Application for a non-material amendment following a grant of planning permission.

Replacement of existing single storey garage and outbuildings with single storey side extension and two storey rear extension.

Reference number: FG/122/17/HH

CH762/003 REV A

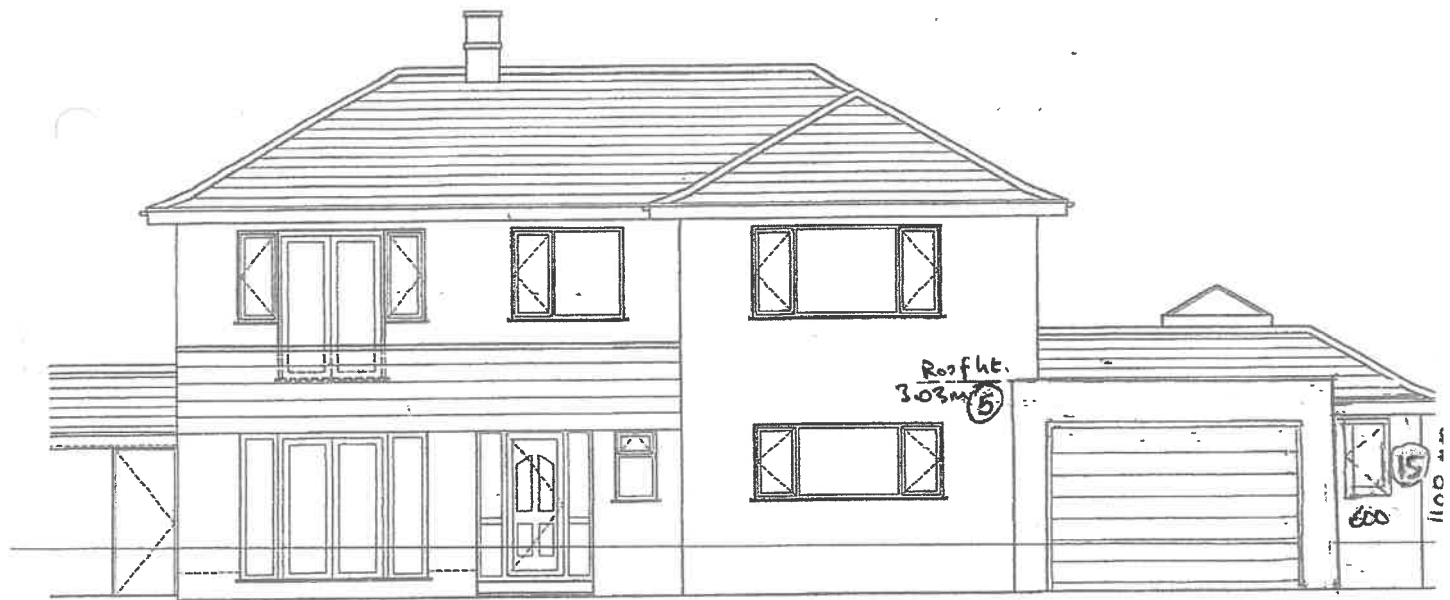
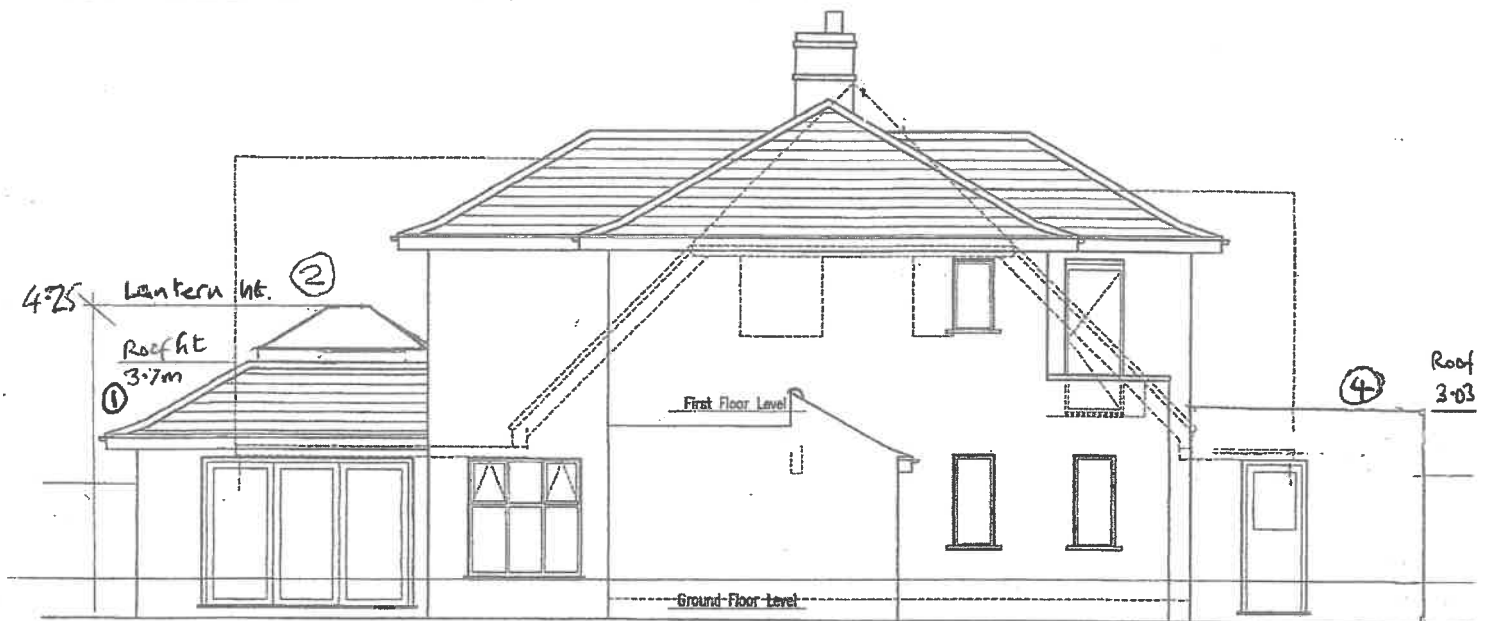
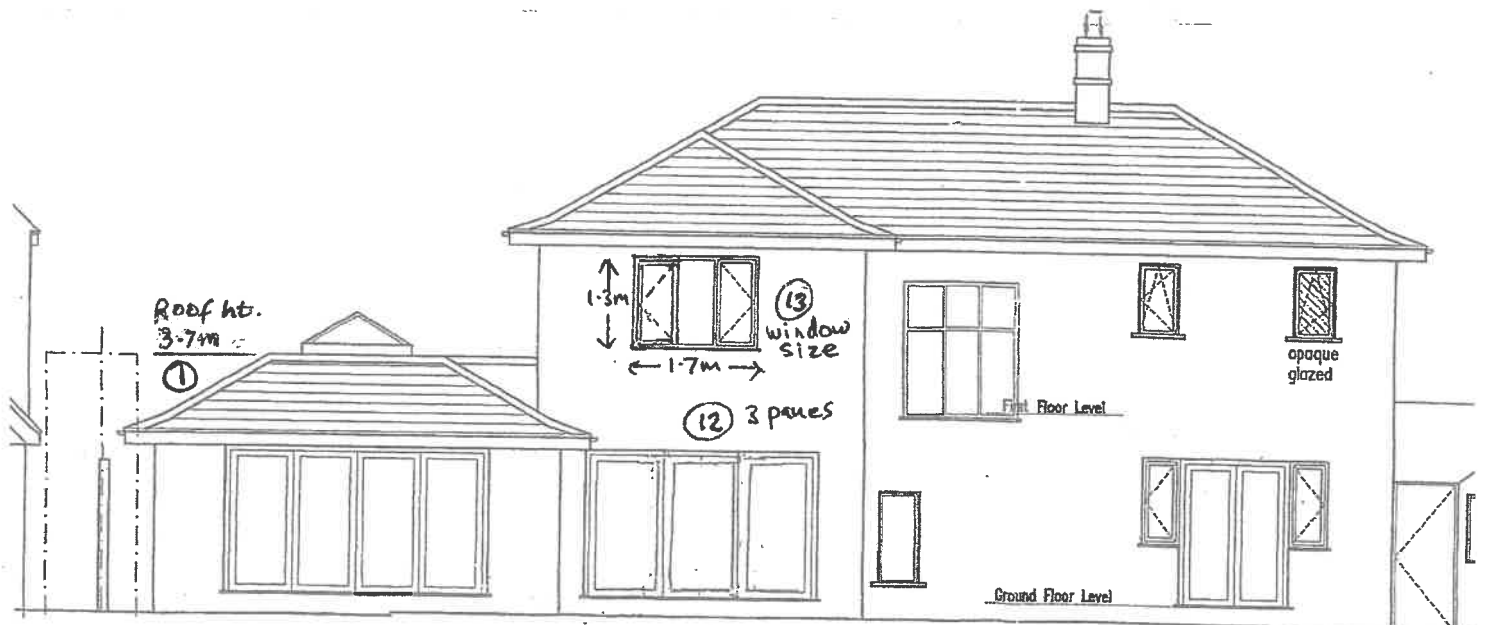
1. Roof height of side extension at front & rear – 3.7m
2. Lantern height – 4.25m
3. Forward projection of garage – 3.08m
4. Height of garage west elevation – 3.03m
5. Height of garage east elevation - 3.03m
6. Floor level of garage below floor level of house - 0.15m
7. Distance of side extension to eastern boundary at the rear - 1.05m
8. Distance of side extension to eastern boundary at the front - 0.66m
9. Garage distance to eastern boundary - 1.69m
10. Width of garage - 4.35m taken by owner
11. Increased dimensions of the lantern window located within the ground floor extension – 2.3 x 1.5m
12. Dining area window to the rear to indicate 3 No. panes within the opening
13. First floor rear bedroom window – 1.7 wide x 1.3m high
14. New roof opening in the front garage extension - 1 x 1m
15. Window instead of door to front of utility room - 1.1 by 0.6m
